January 24, 2024

RE: Responses to Technical Review 1
White Barn Brown Bear Car Wash
8907 & 8915 Soper Hill Rd
City File No. PA23-021
Our Job No. 22681

Letter from City of Marysville dated December 5, 2023

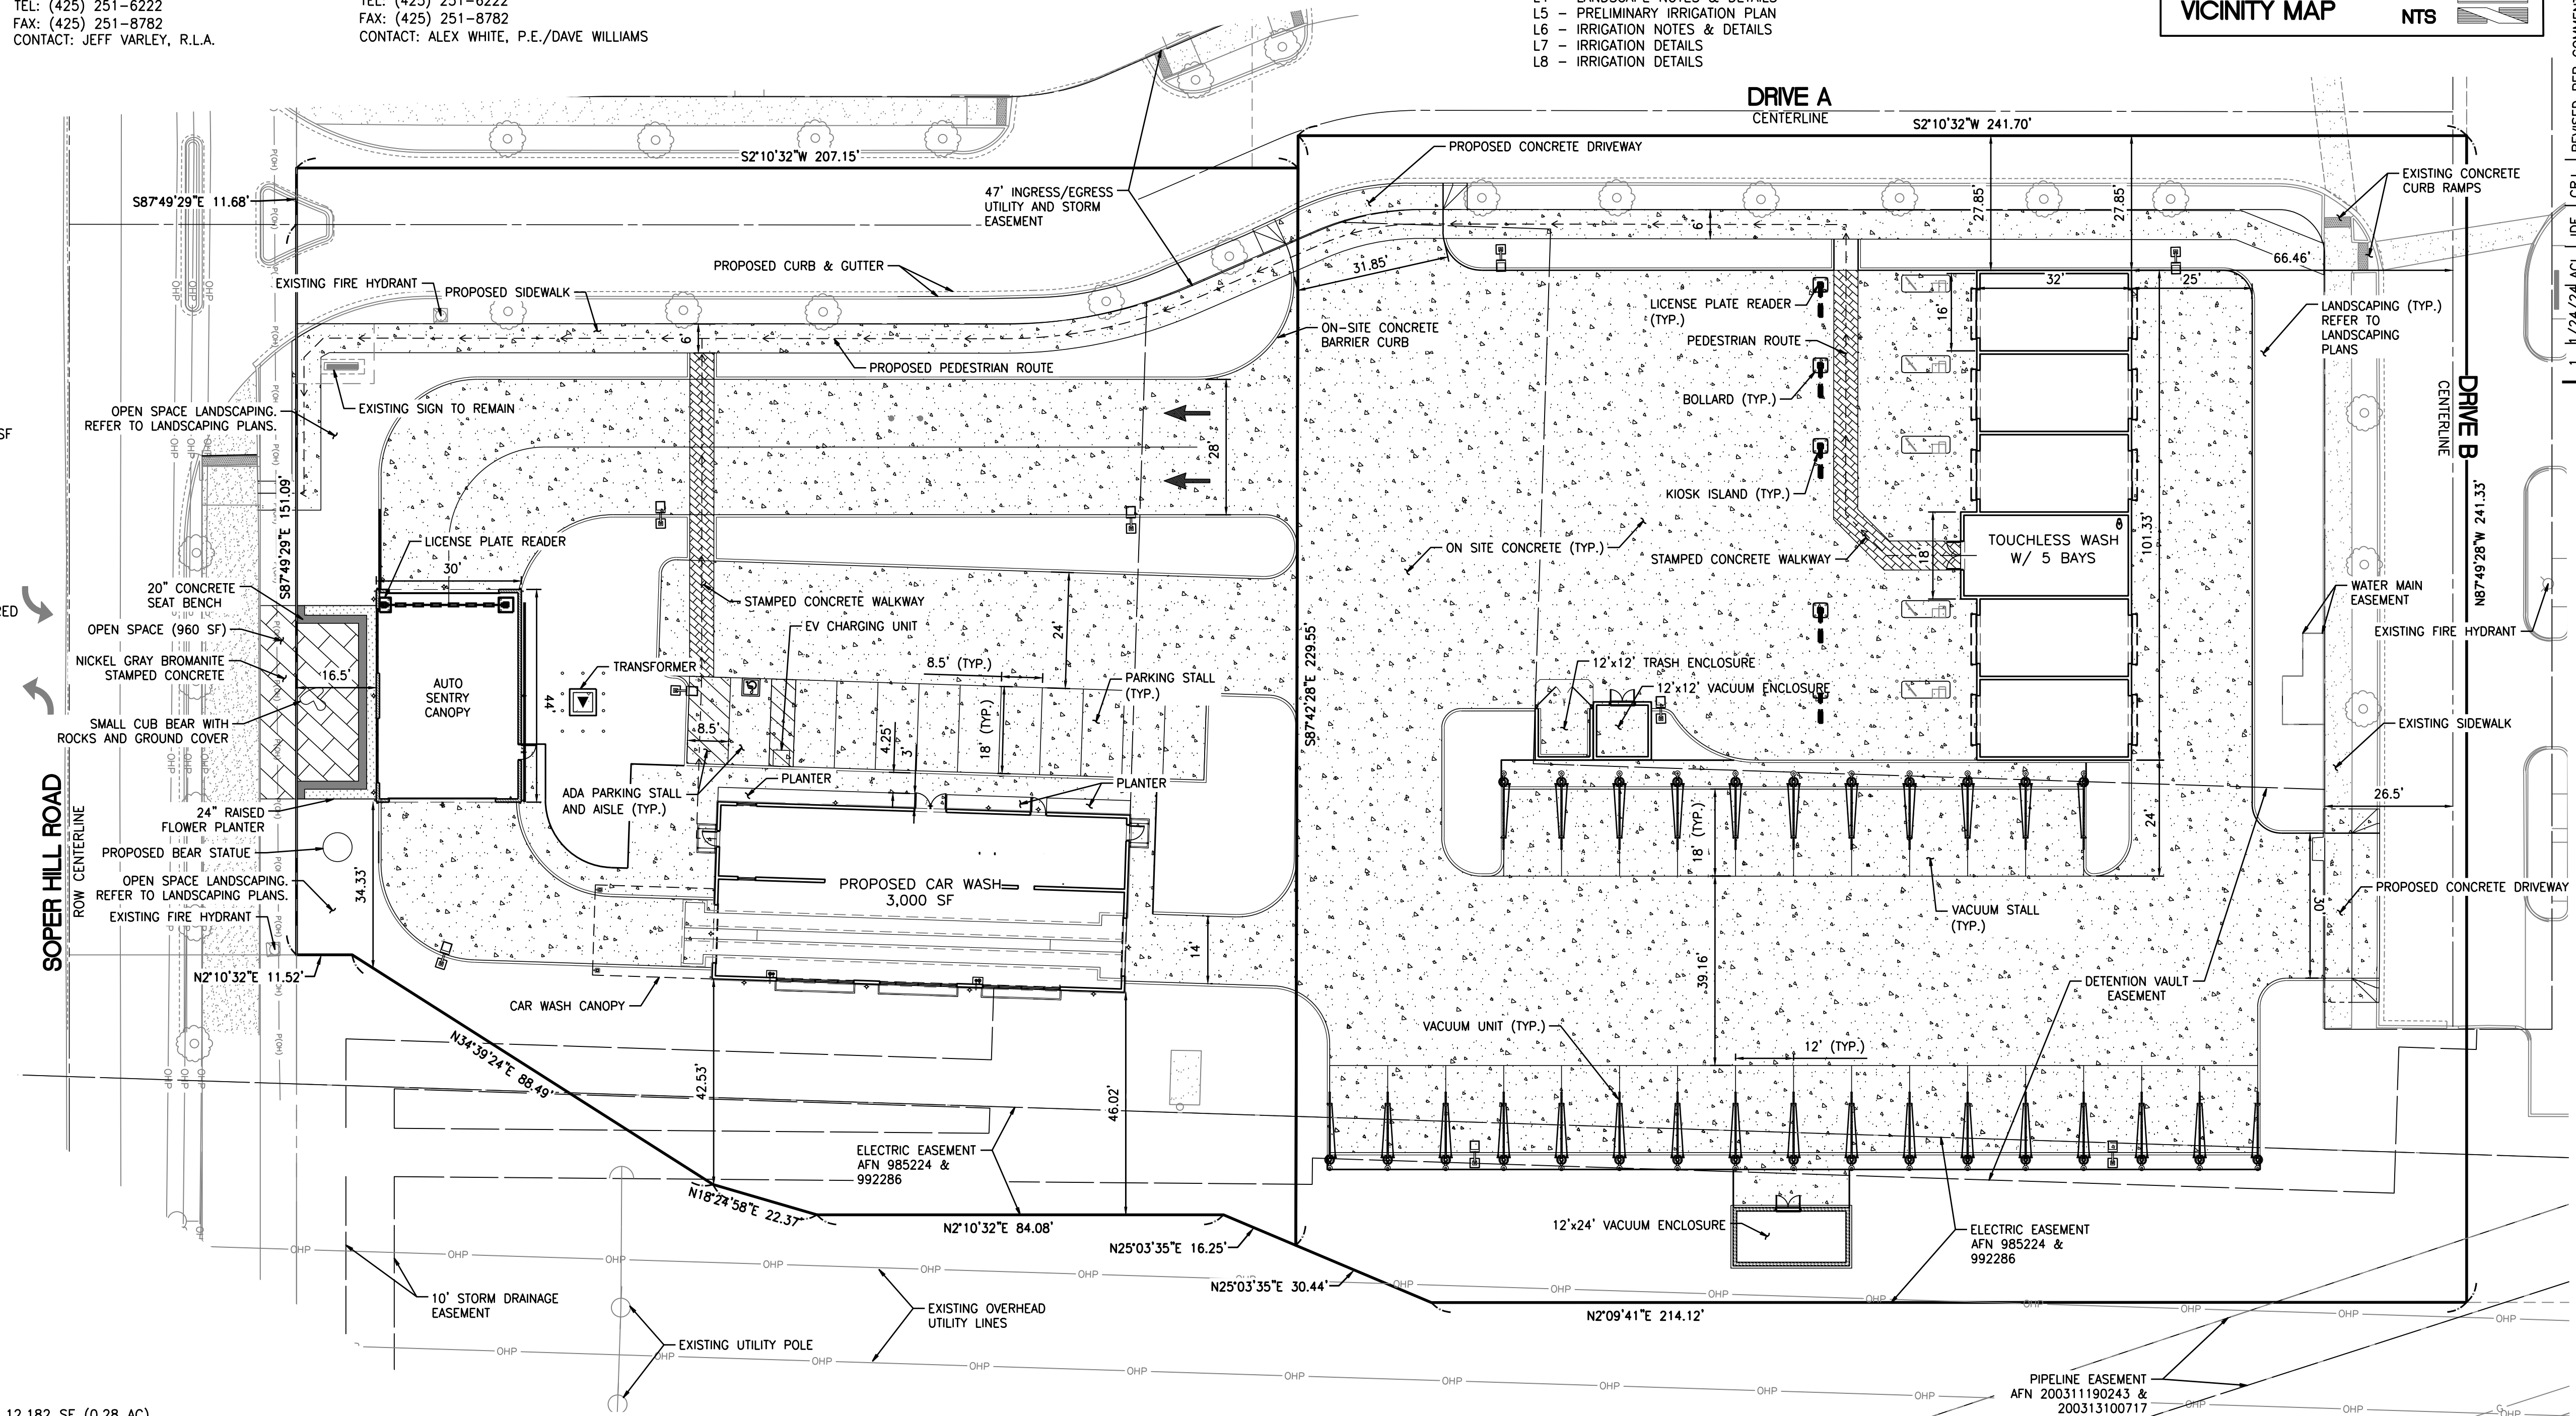
2. *Car washes are required to meet the design standards of MMC 22C.020.265. Please demonstrate compliance with the following:*
 - 2.1. *A 3 ft. wide strip of foundation landscaping shall be provided along at least 50 percent of the building's front elevation.*
 - 2.2. *A 2 ft. plus border of textured paving should be provided around the touchless wash building. Further, the noted "Pedestrian Route" should be clearly depicted with stamped concrete.*

3. *There should be a pedestrian connection from the Main Car Wash Building to the island south of the vacuum station. As a method to satisfy the above comment 2.2 as well as this pedestrian connectivity issue, staff suggests the following revision:*

Response: A 3-foot-wide planter has been added to the front of the car wash refer to sheet C1.0. Additionally, the pedestrian route from Drive A to the touchless car wash bays has been revised to stamped concrete, refer to sheet C1.0.

Response: Refer to sheet C1.0, the pedestrian route from Drive A to the touchless car wash bays has been revised to stamped concrete.

**PRELIMINARY UTILITY PLAN**  
 FOR  
**BROWN BEAR CAR WASH**  
 SE 1/4 OF NW 1/4 OF SEC. 1, TWN. 29 N, RGE. 5 E, W.M.  
 CITY OF MARYSVILLE, SNOHOMISH COUNTY, WASHINGTON

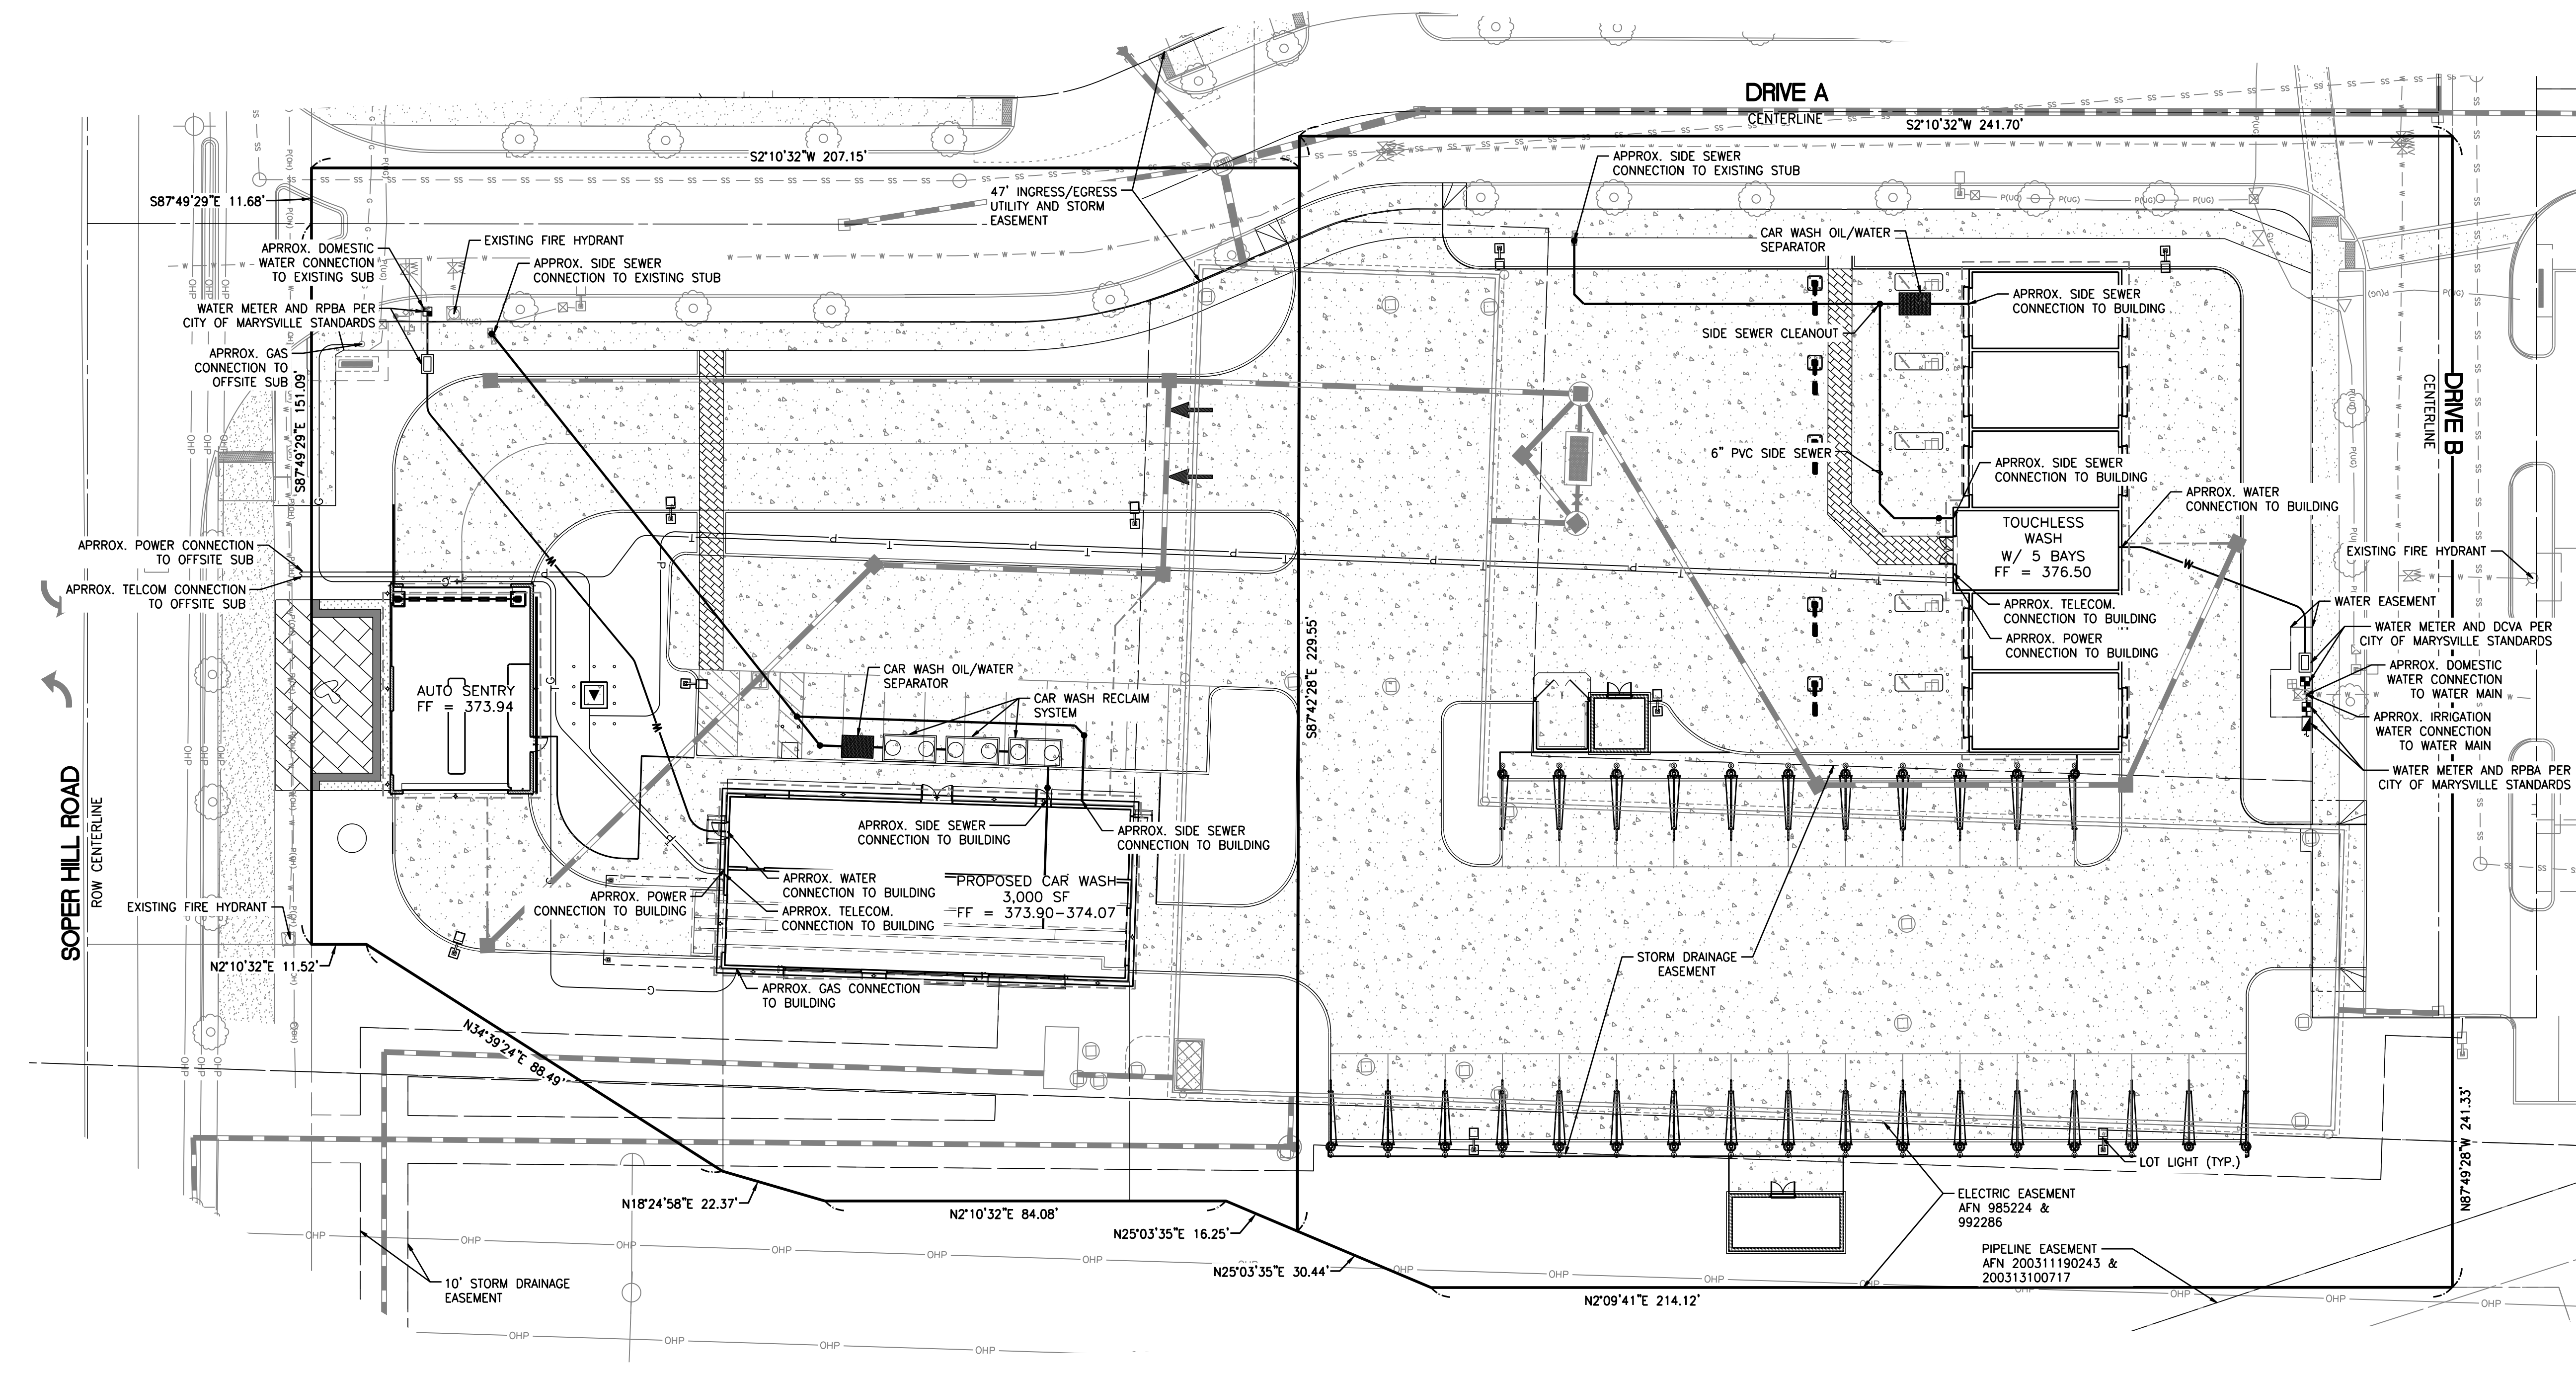
2. *This is a table 9 facility requiring a RPBA directly downstream of the domestic water meter. For the purpose of premise isolation of the domestic water line.*

Response: Acknowledged. A RPBA will be installed downstream of the water meter for this development, refer to sheet C4.0.
